The Limes 51 High Road

**Sent:** 27 August 2009 16:26  
**To:** Planning  
**Subject:** Welwyn Hatfield Council Online Planning - Comment

Application Number: S6/2009/1501/FP  
Name: simon cadisch  
Address: the vines  
essendon  
herts  
al96hs

PROPOSED PLANS & BLOCK PLAN

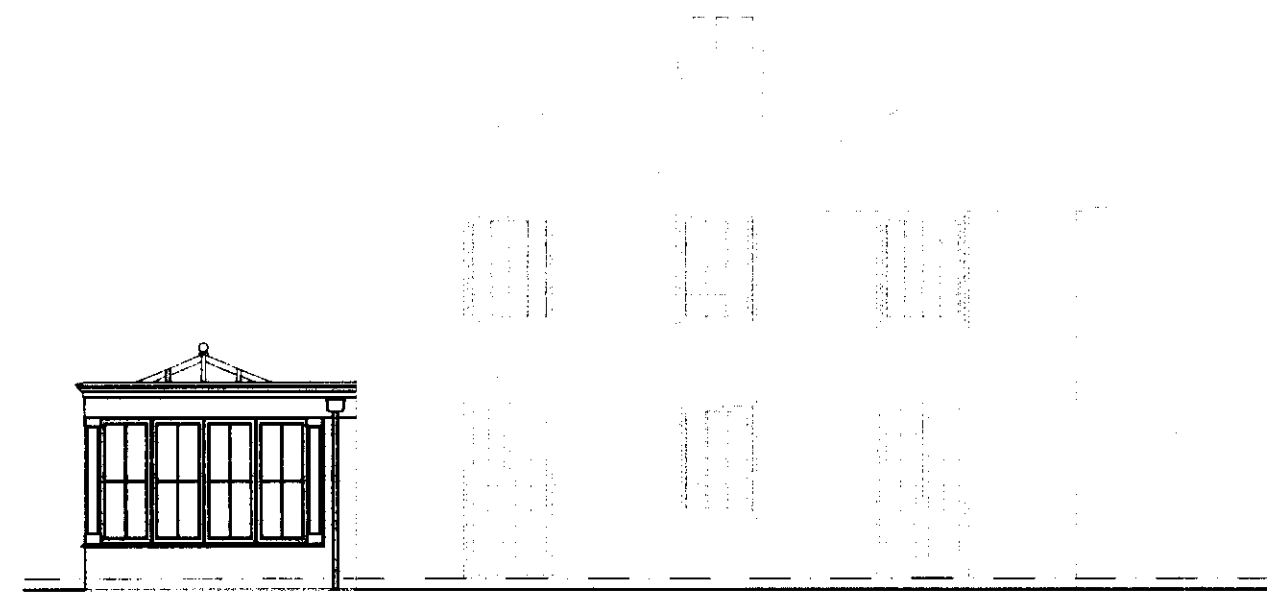
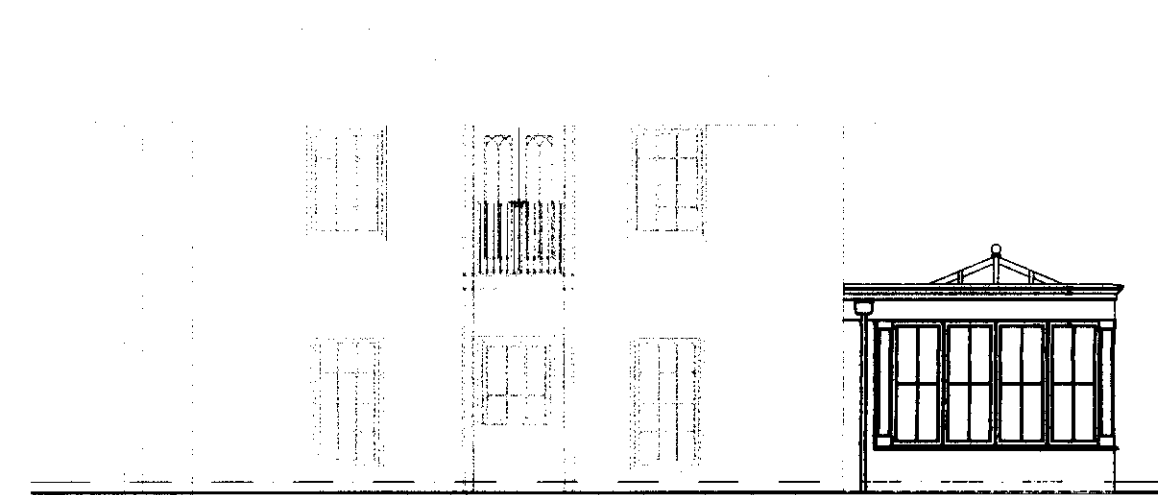
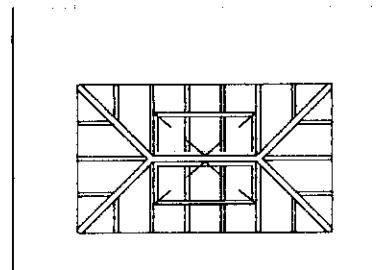
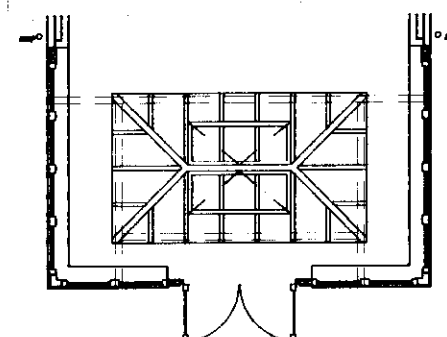
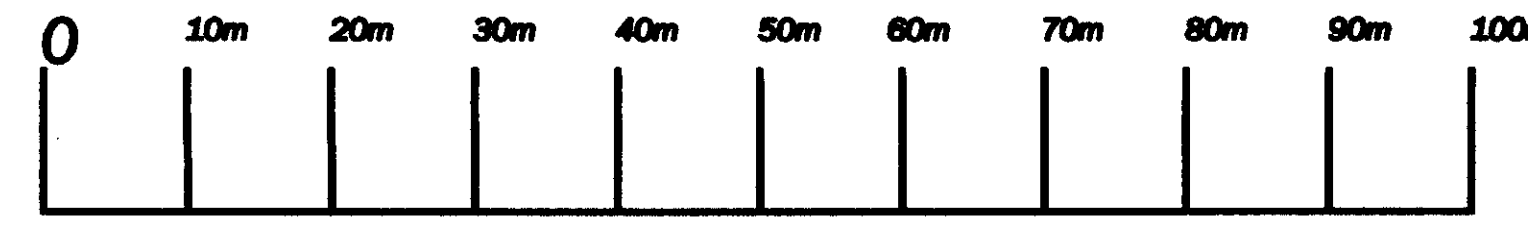
This new application requests another very significant addition to the already much enlarged footprint of the building (by my estimate another 30%) which contravenes planning guidelines as well as looking out of proportion to the rest of the dwelling. The application suggests that this new addition would not be visible from the public highway but this is not correct.
